Your ref: SSD-80287510
Our ref: MC-25-00008

**Re: SSD-8-287510 – Residential development with infill affordable housing,
84 Tallawong Road, Rouse Hill**

Blacktown Council's submission to SSD-8-287510 – Residential development with infill affordable housing, 84 Tallawong Road, Rouse Hill

Figure 16 Site Catchment Plan

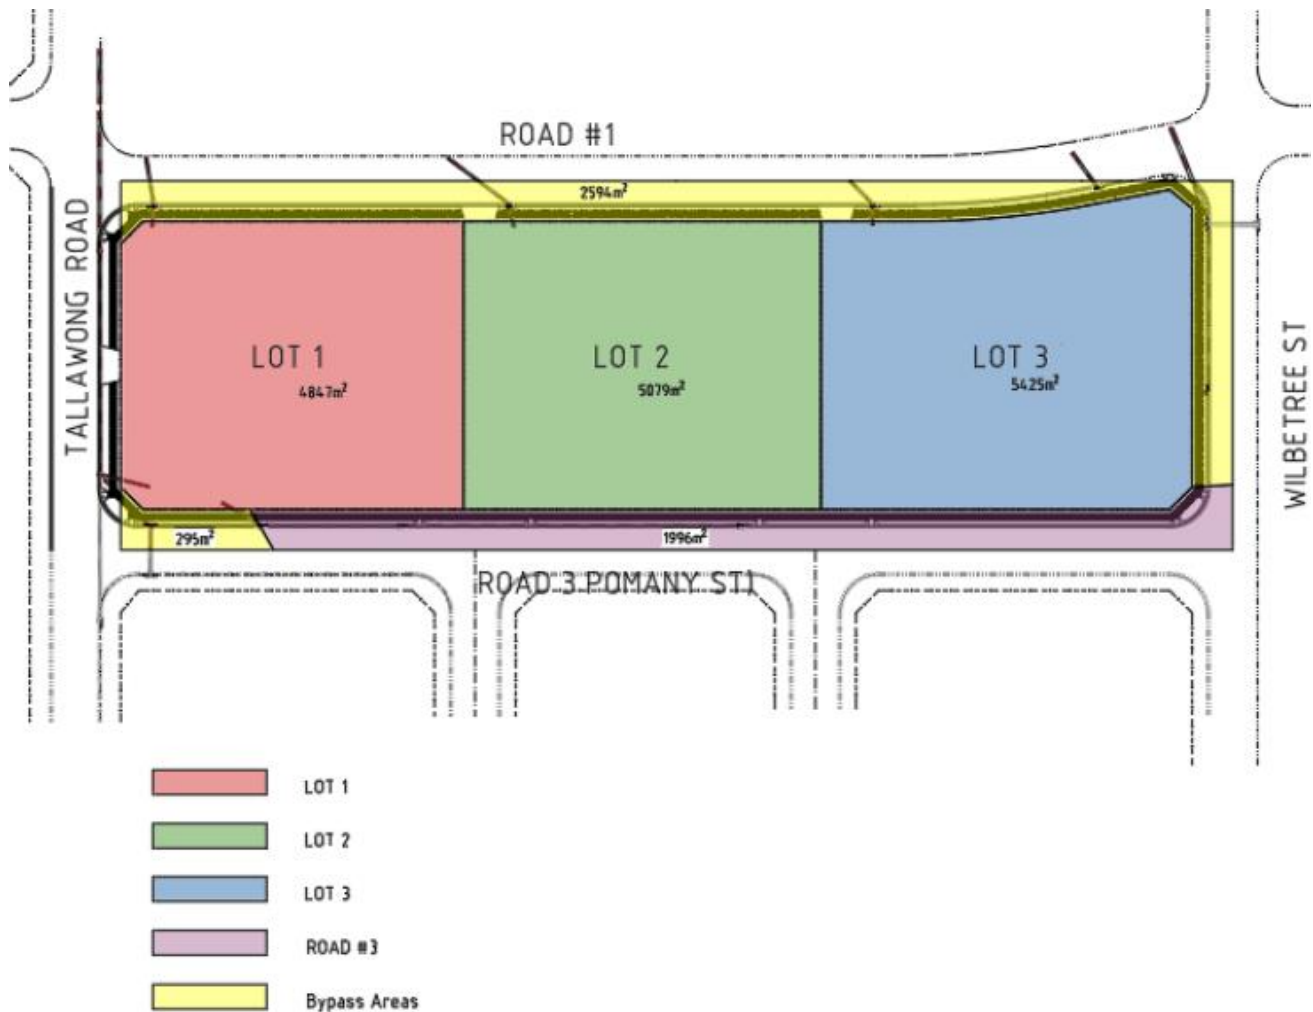
- b. The submitted Civil drawing, C&M consulting, drawing Number 02175, Rev 1 and dated 1/04/25 has been reviewed. However, it is insufficient for assessment on the proposed drainage design. A full set of the civil design must be provided including the future pit and pipe of the road 1 and the nearby section of Tallawong Road.
- c. Additionally, the change of the business use must be addressed on the water conservation and rainwater tank design.

Figure 17 Affordable units diagram

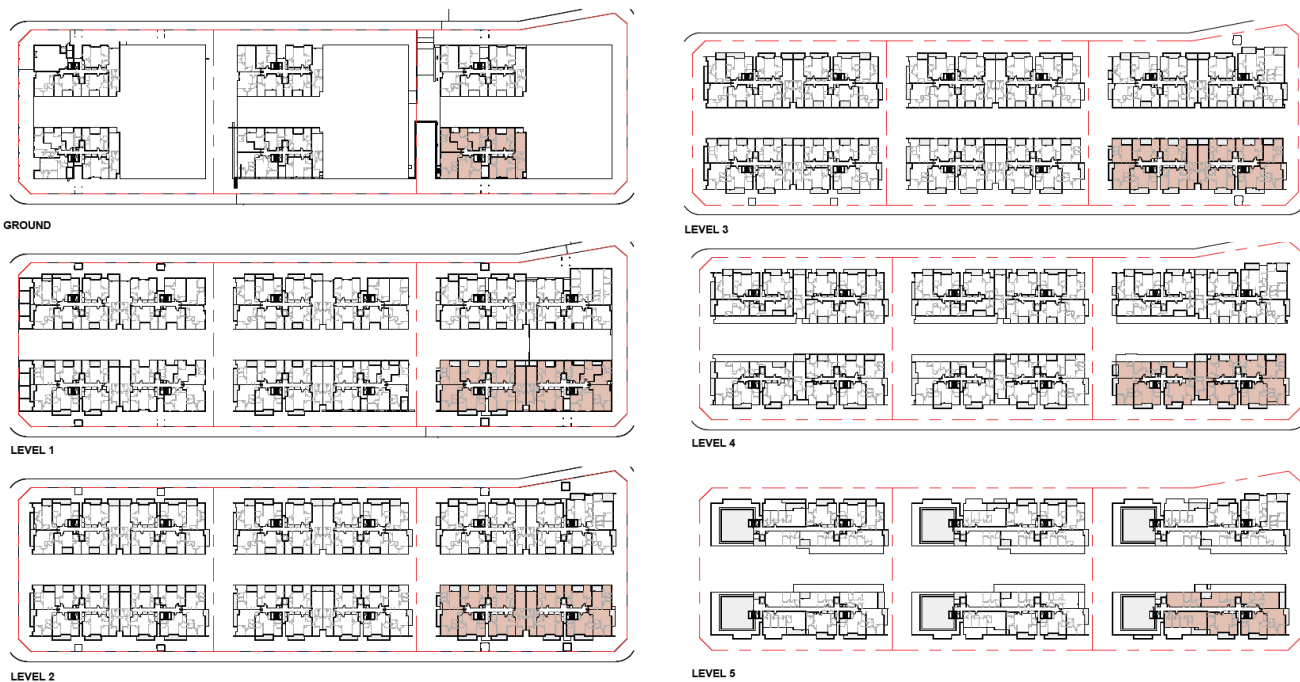
In accordance with requirements of the SEPP (Housing) 2021 (2.1.15), evidenced best practice and the recommendations outlined in the REF, the concentration and dispersion of the affordable units should be separated across the site. The project is supported by HAFF funding, which provides financial assistance to the CHP for the length of affordable housing management. Social Planning is not satisfied by the justification that potential management costs outweigh the known negative implications on residents and community that result from the concentration of units. This lack of best practice approach by the CHP raises concern for the future tenancy management of these residents. With the support of the HAFF funding and the known benefits of scattering the affordable dwellings the applicant must revise the scheme.

Social Planning is strongly opposed to the concentration of the affordable dwellings, if these dwellings can be better dispersed through the six residential flat buildings the proposal will achieve a good quality outcome and be a positive addition to the community, this change will allow for the full support of the social planning team. The additional items raised can be resolved through minor amendments to the design or additional details provided.
